FW: P/5/26/PL

I'm just about to head on site and post the notices for this application, but in reviewing the description and given the size of the rear dormer proposed to the existing bungalow, I think it is worth including a specific reference to the inclusion of the dormer extension within the description and on the notices to be posted.

'1 No 4-bed chalet bungalow, alteration of existing bungalow to include off-street parking and rear dormer extension (resubmission following P/118/25/PL). This application is in CIL Zone 4 and is CIL Liable as a new dwelling.'

Proposed West Elevation 44

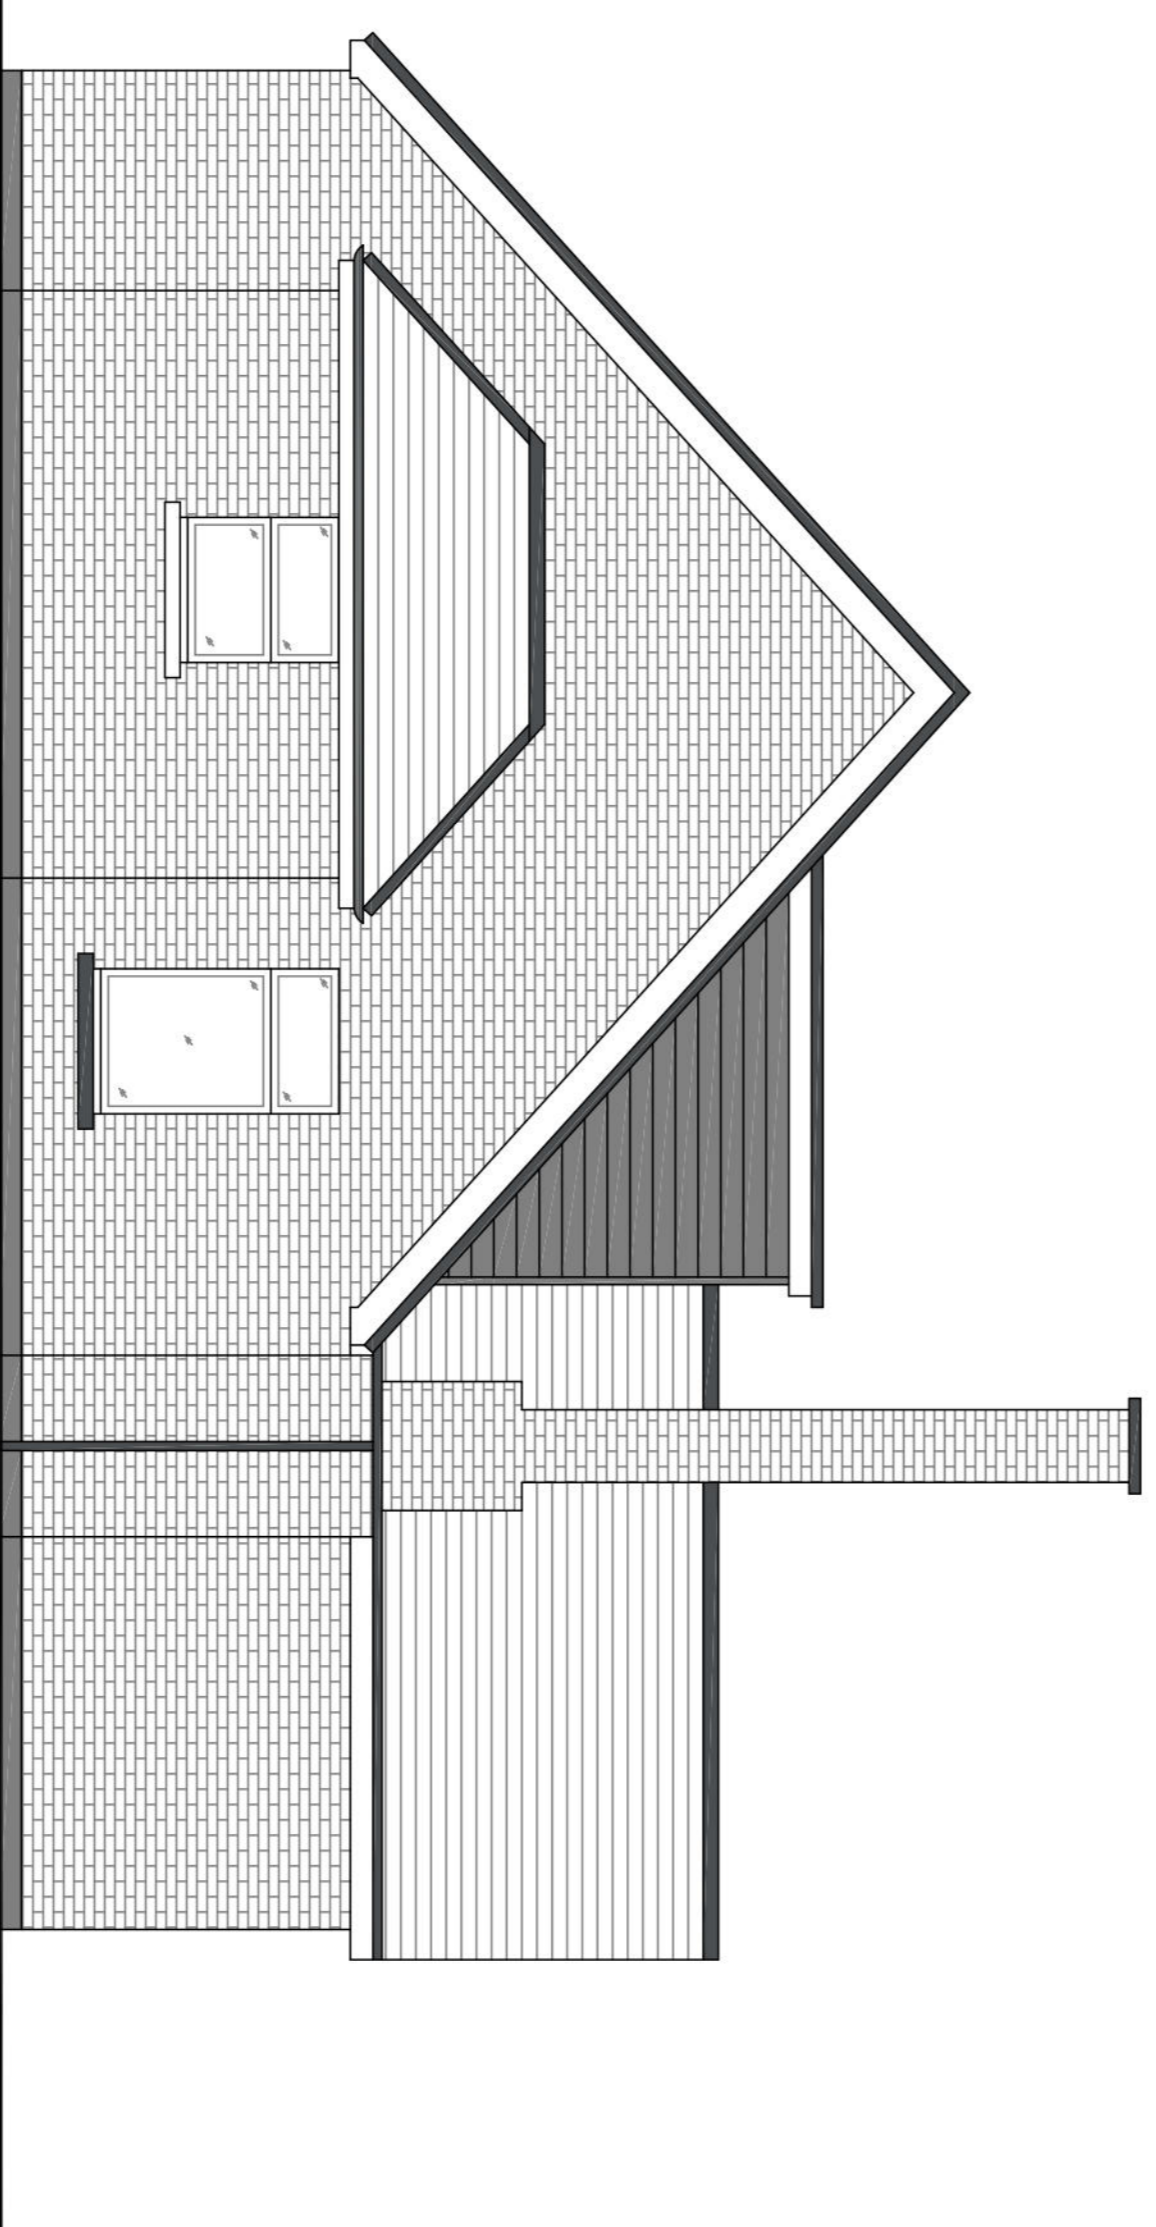
Following review, could I request that the rear dormers of both dwellings are reduced in width, perhaps at least by 0.5m each side, and that they are set back into the roof slope slightly further by perhaps a couple of rows of tiles. Our aim is to reduce their dominance of the rear roof slopes.
